20 December 2010

Our Ref: C10/7304 & 2008/0189V2

RE: Part 3A Major Project Application MP 10_0104 – Exhibition of Circular Quay Public Domain Upgrade Works, Circular Quay/The Rocks

7. Lighting

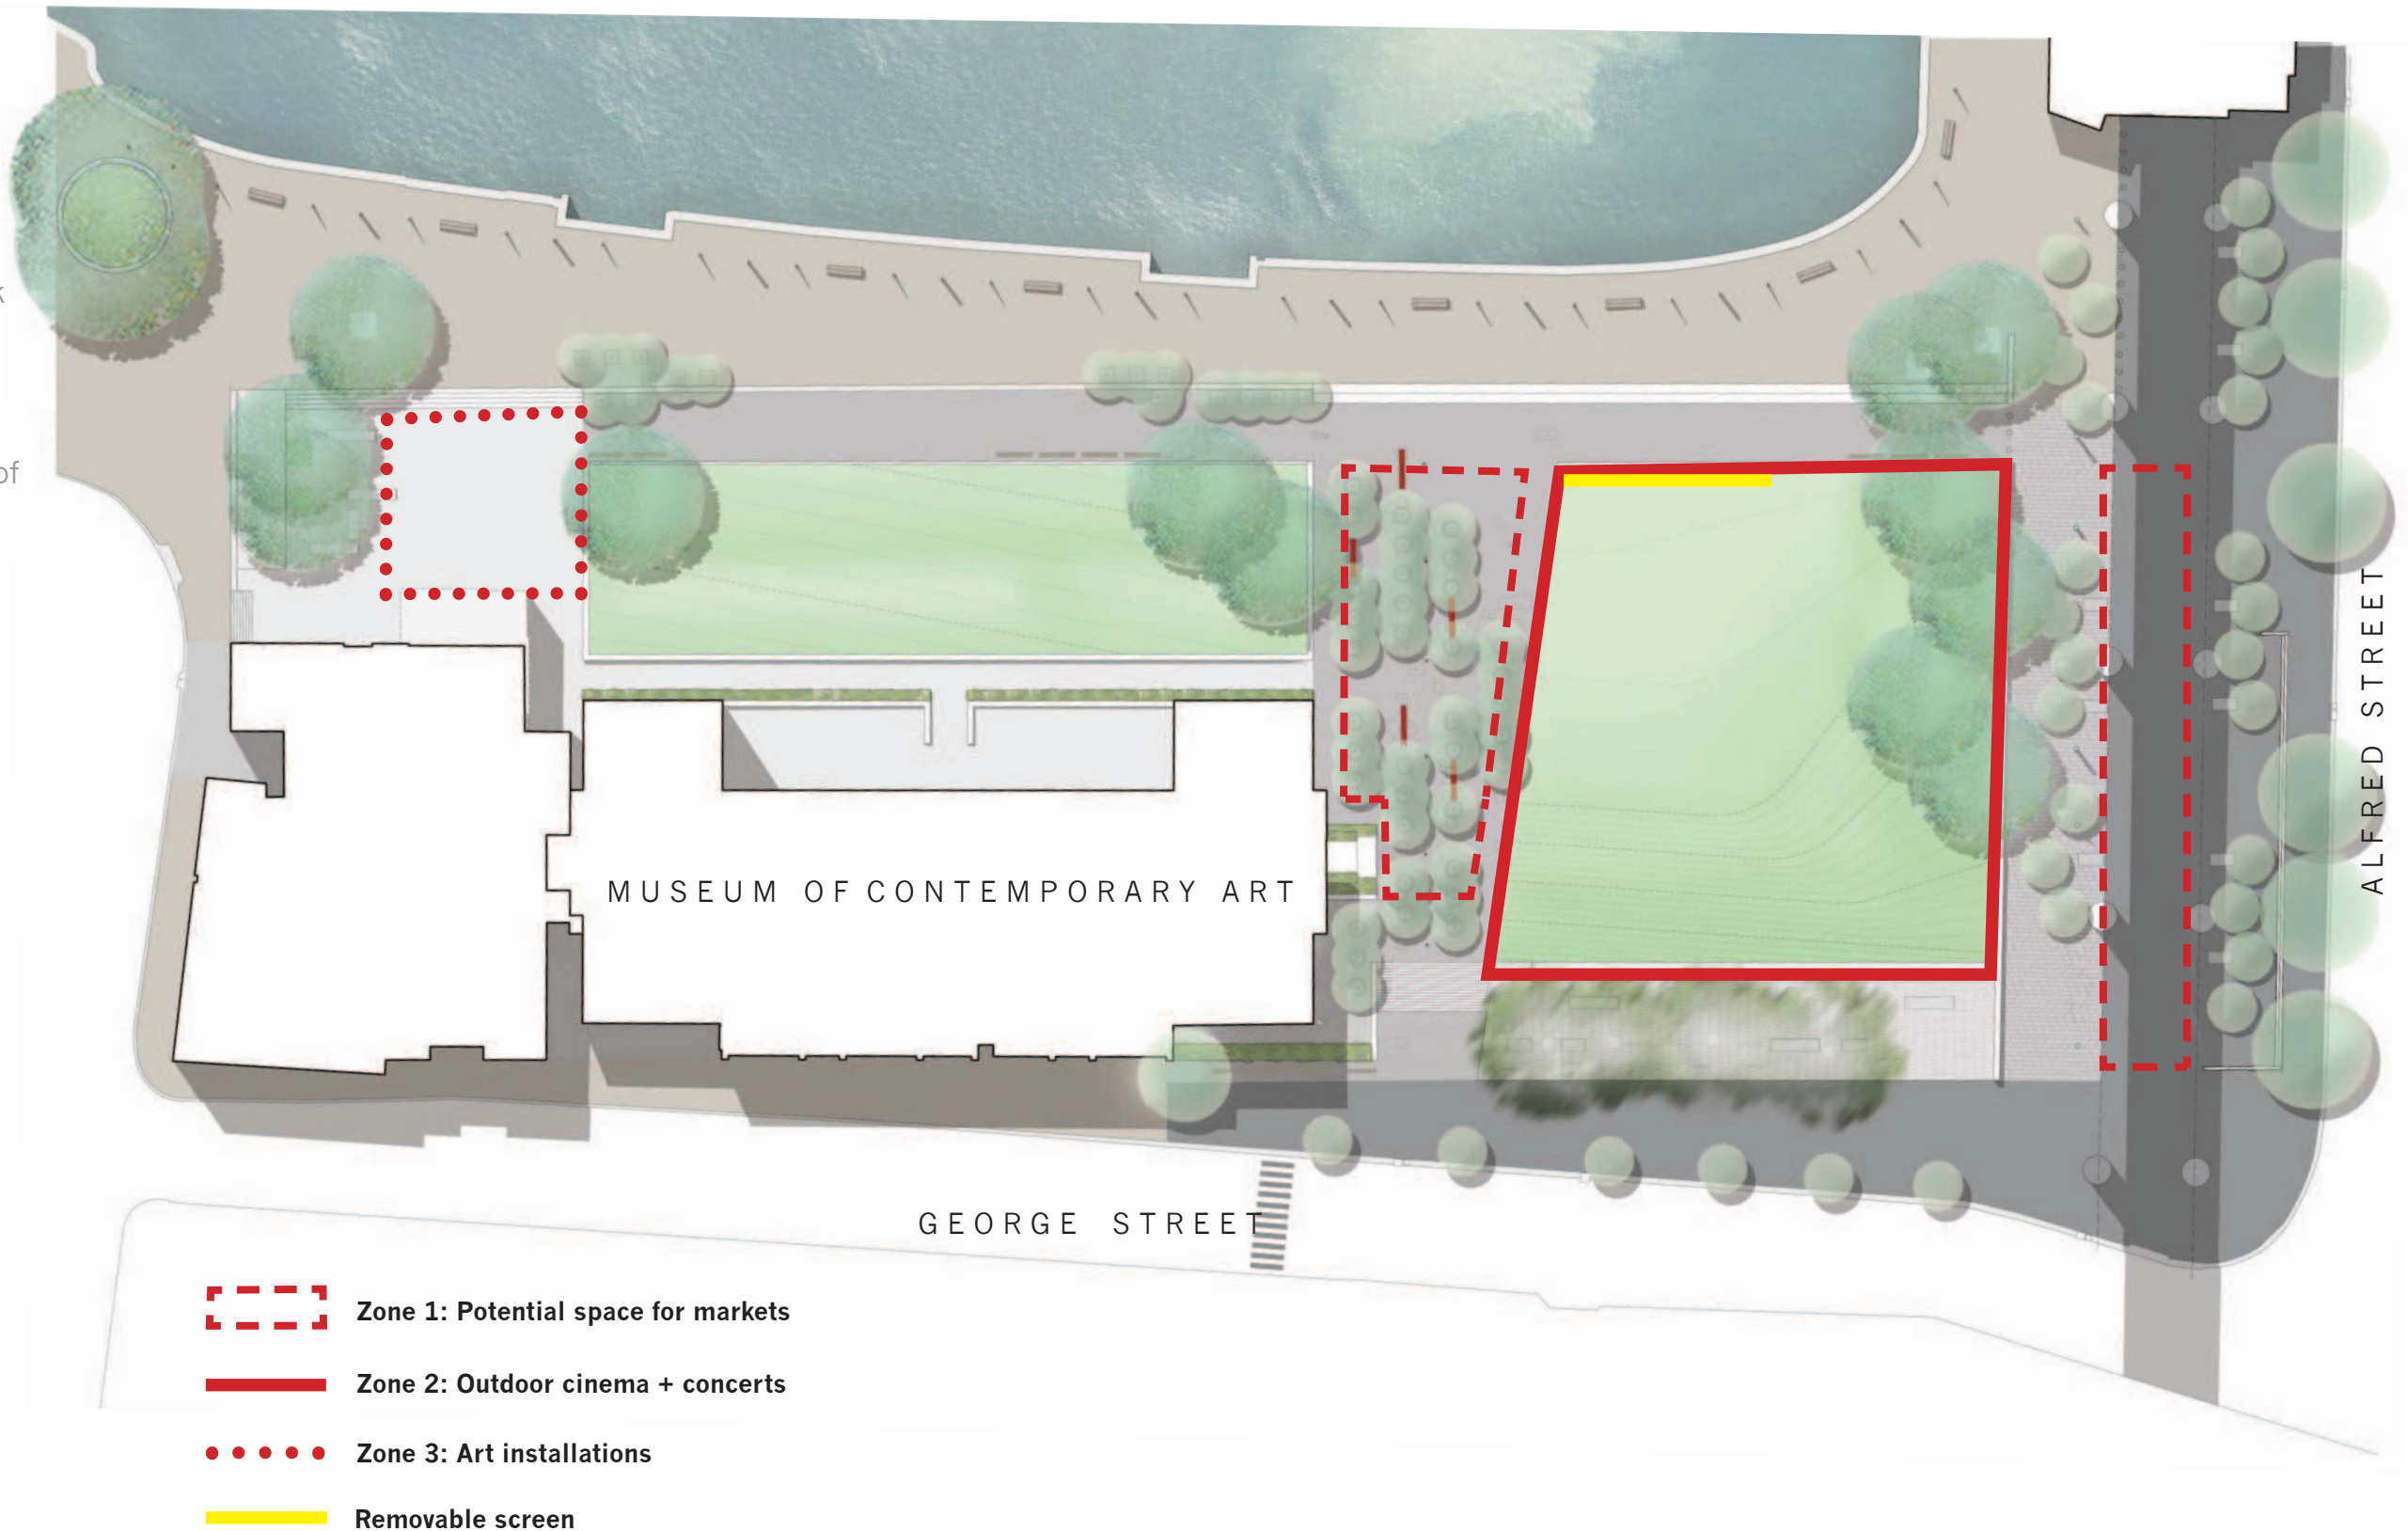
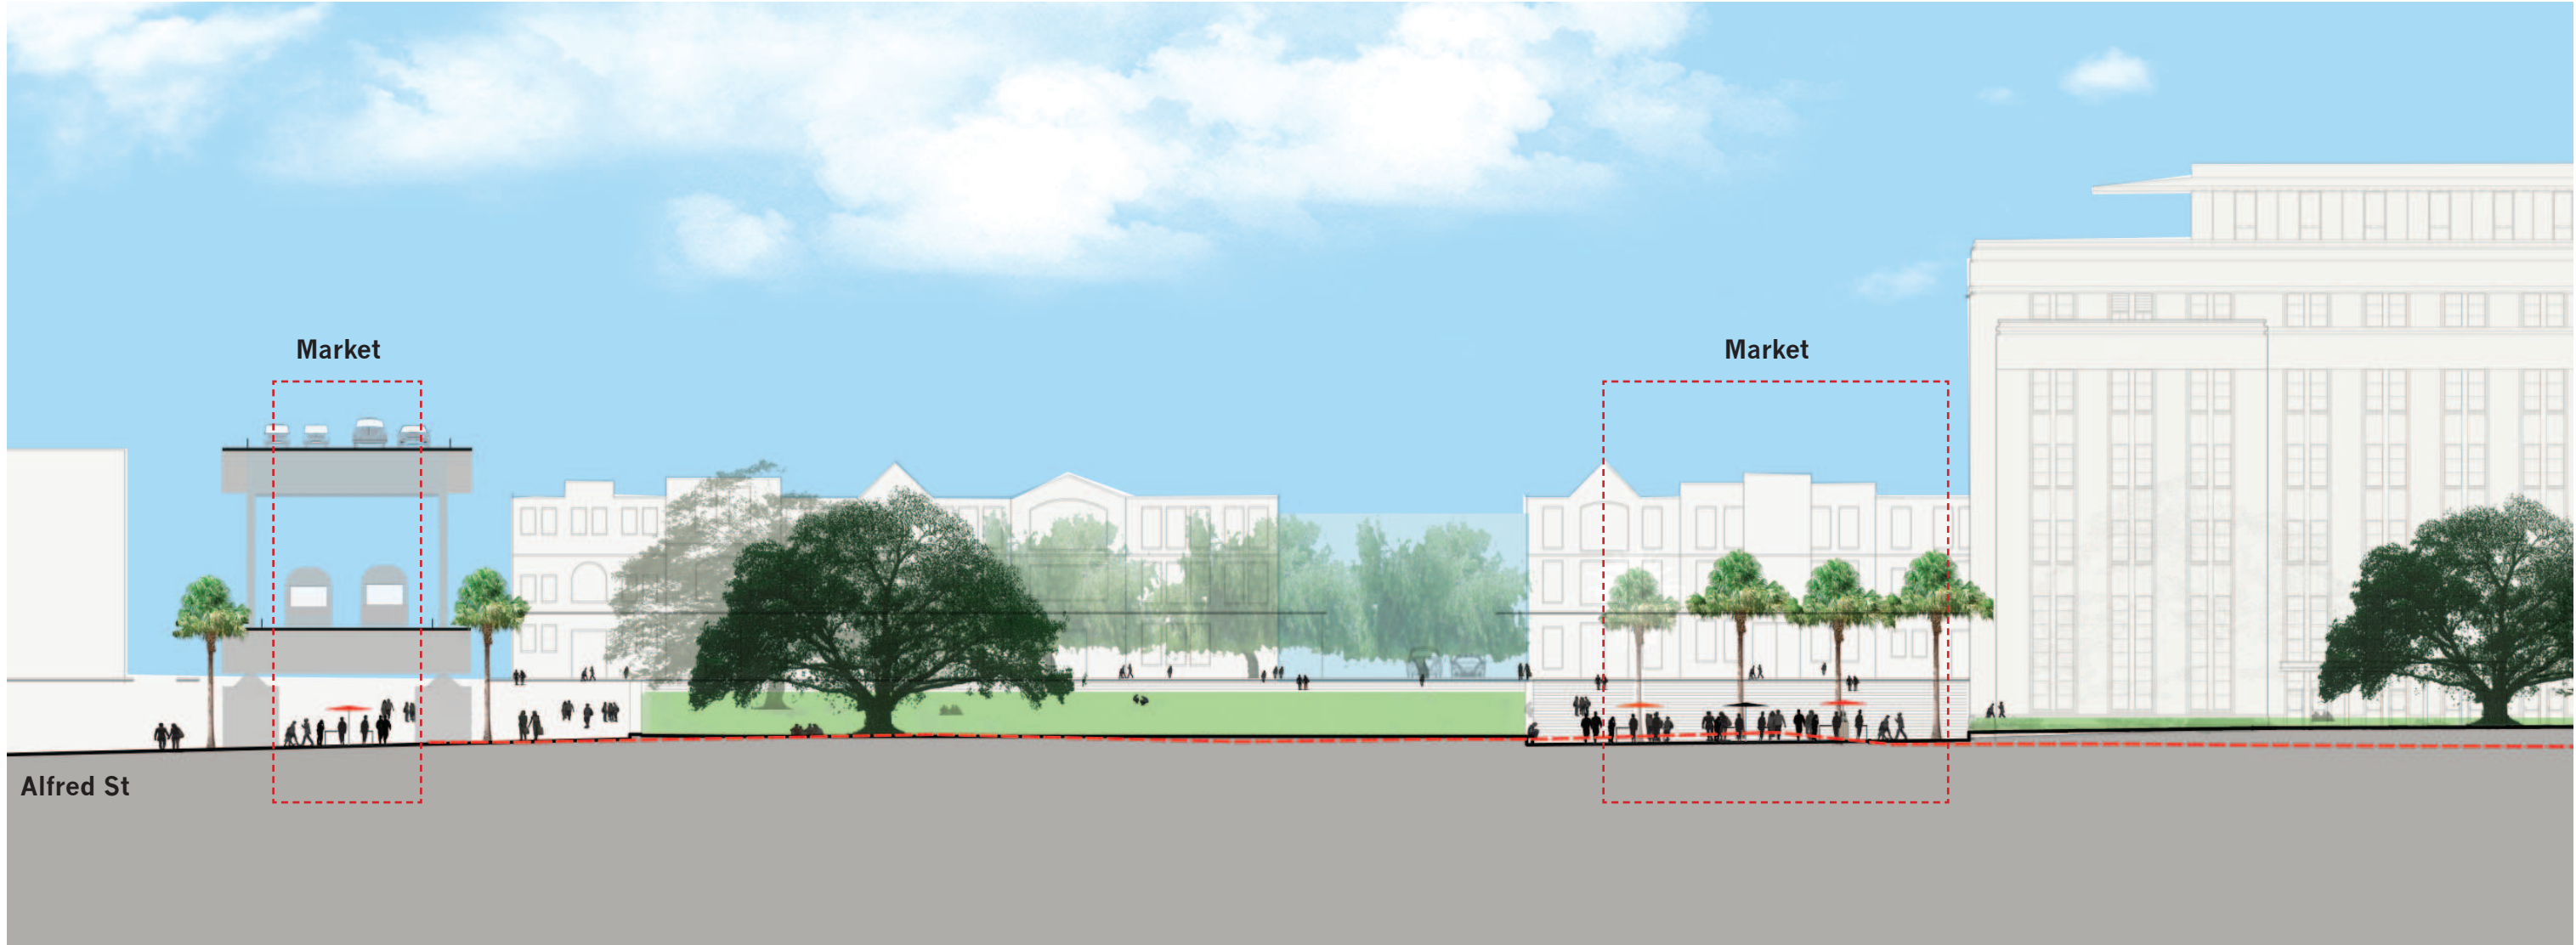
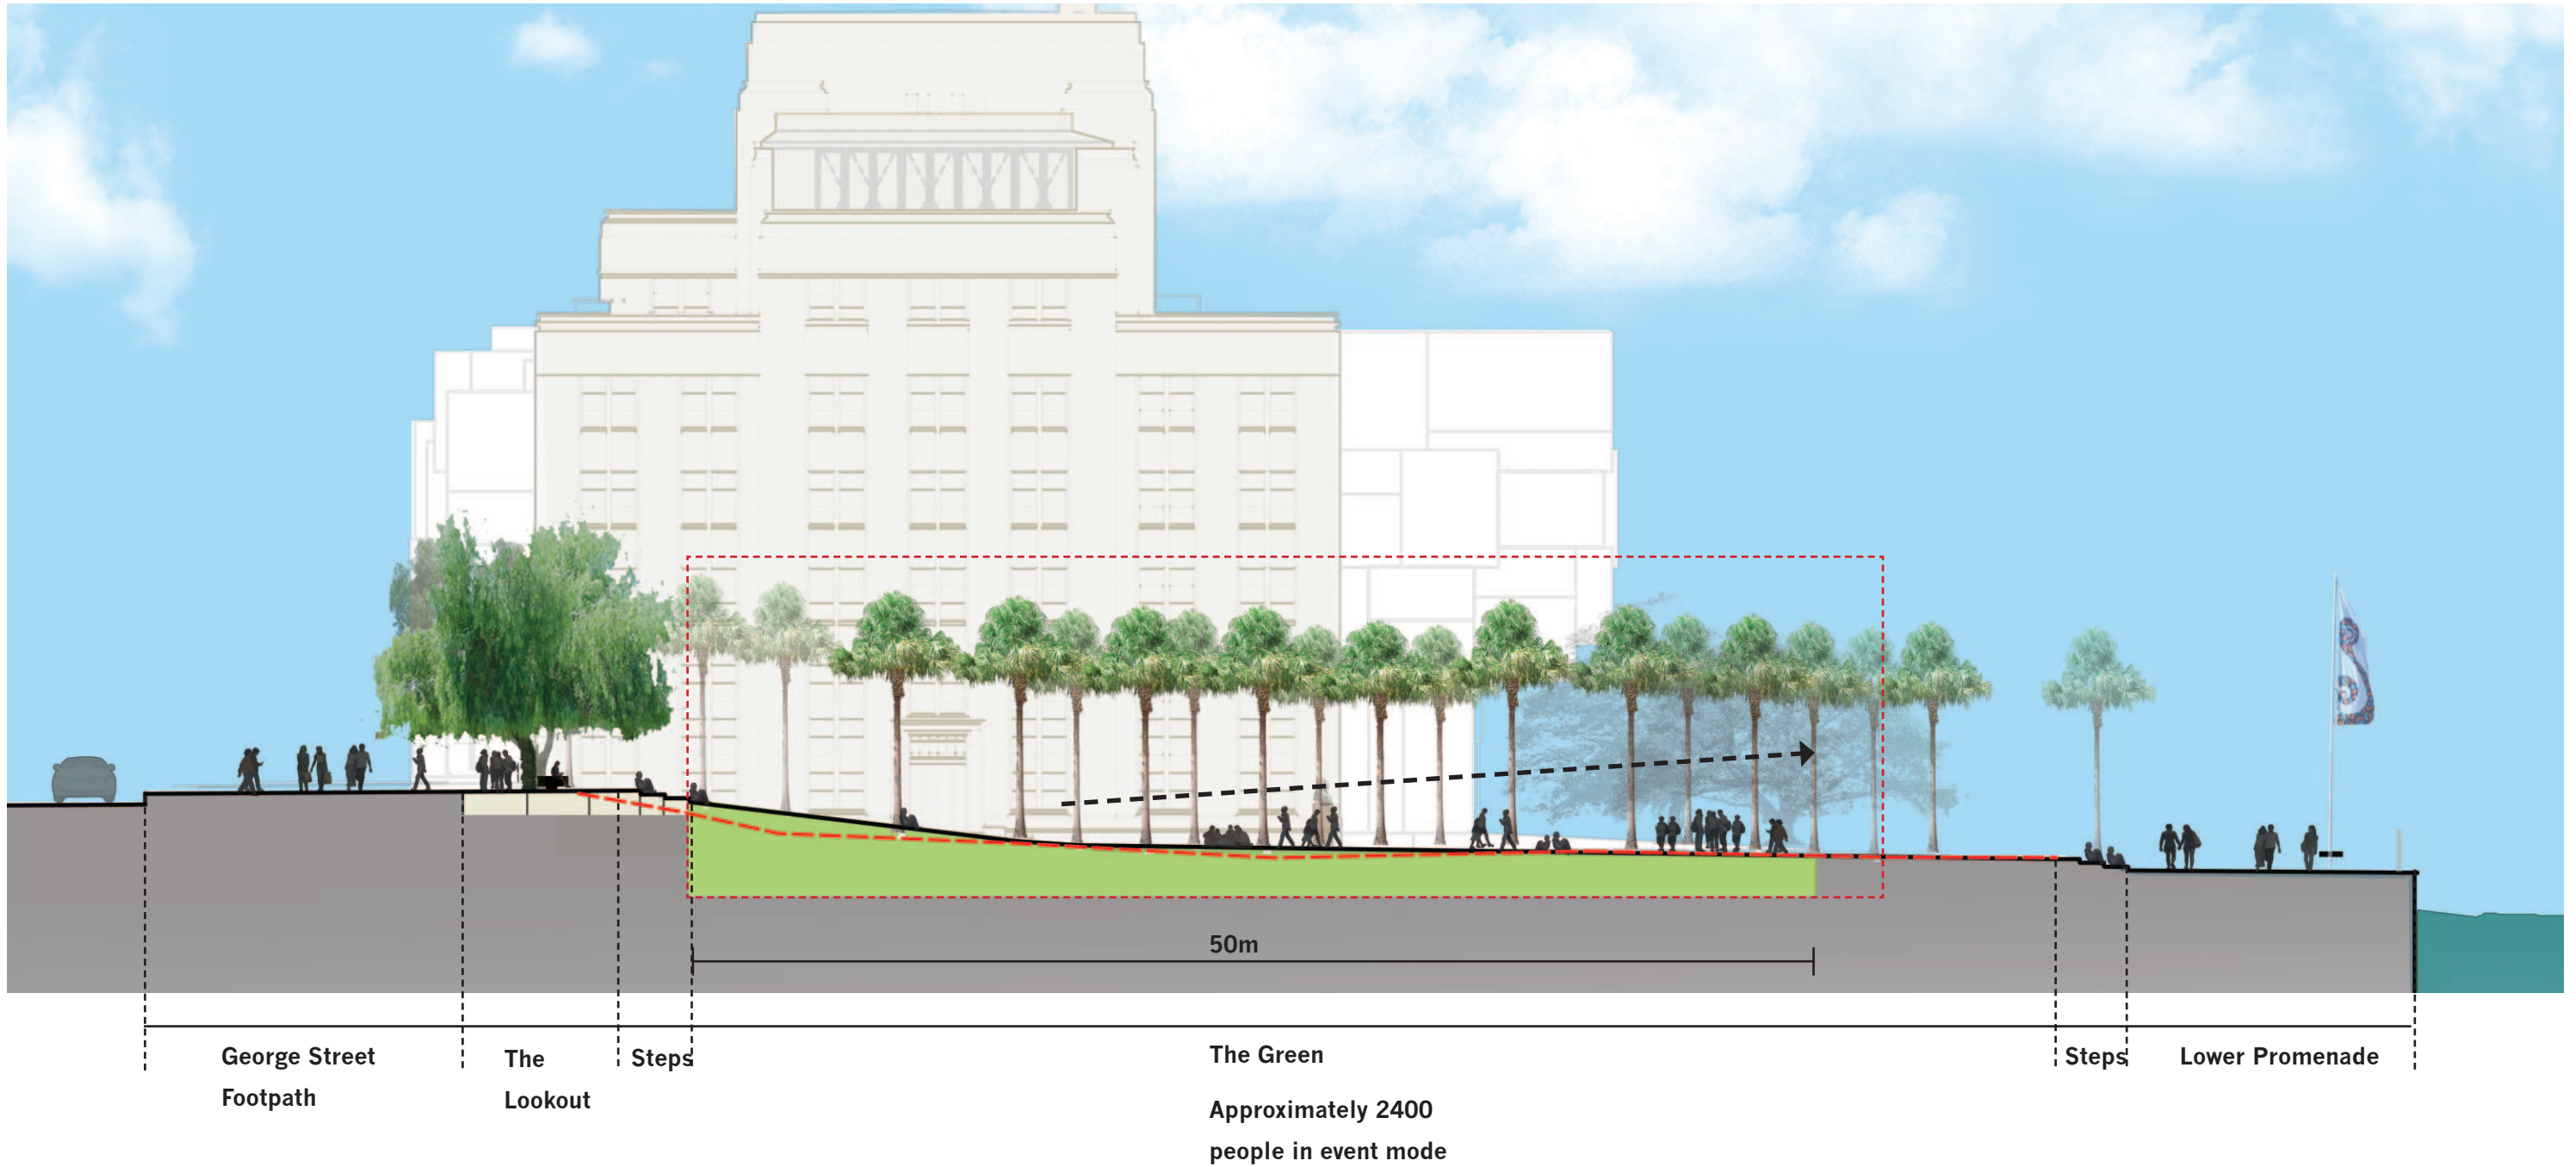
Sydney Ports is of the opinion that the potential navigation impacts on safe shipping movements proposed lighting has not been addressed as previously requested by Sydney Ports. Sydney Ports requests that a condition be imposed, if approved, that any proposed lighting needs to be downward facing or not directed towards the water/OPT to ensure no horizontal light spill occurs, which could impact on shipping navigation and safety.
